RFI

RFI #: 135
 Date: 5/31/2012
 Job: EB-02 Keller Springs Lofts
 Phone: 877-777-5115

Subject: Slab at Club Poured Short

TV SELECTIONS WERE BASED UPON THE FOLLOWING (IN ORDER OF IMPORTANCE):

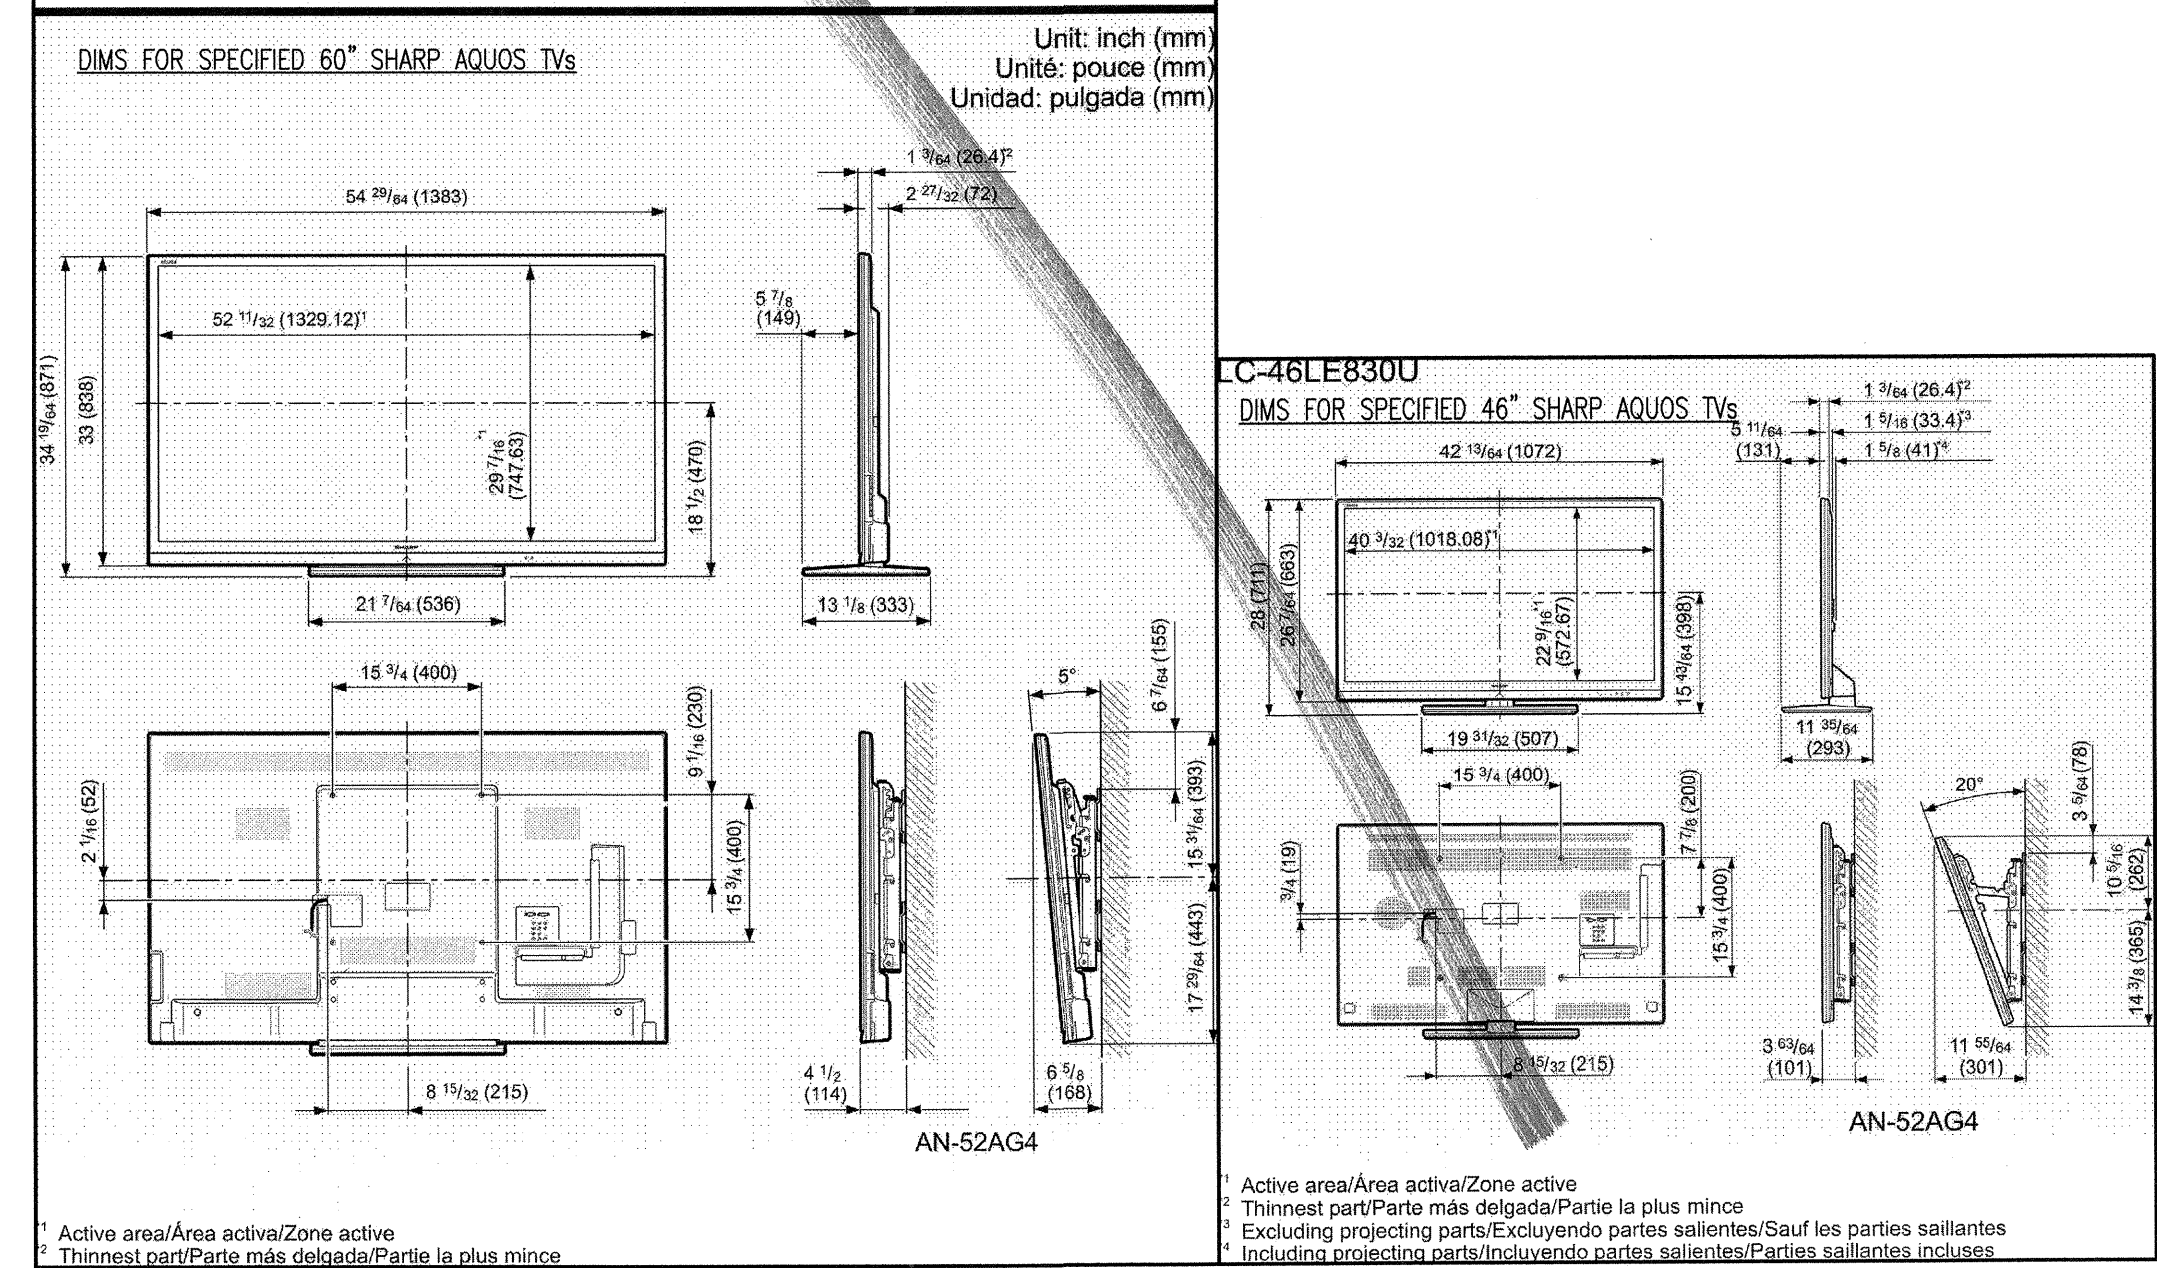
Subject: Great Room TV / Proper Rating for Wall

Drawing: A9.1, 4/ID7.0 & 3/ID7.2
 Cost Impact: None
 Spec Section:
 Schedule Impact: None

Request:
 Please confirm that we have the rating we need for the 2 HR separation wall as it is drawn by in Interior Designer. Please see the attached drawings.

Response:
 There are two stud walls in this area, and working with Les Wagoner (Embrey), we have coordinated that the 2hr UL wall assembly will go on the unit side stud wall in this area to allow for ID's detail to not affect the 2hr assembly. Les has confirmed that the 2hr assembly will be continuous around the club no matter which direction the 2hr wall turns.
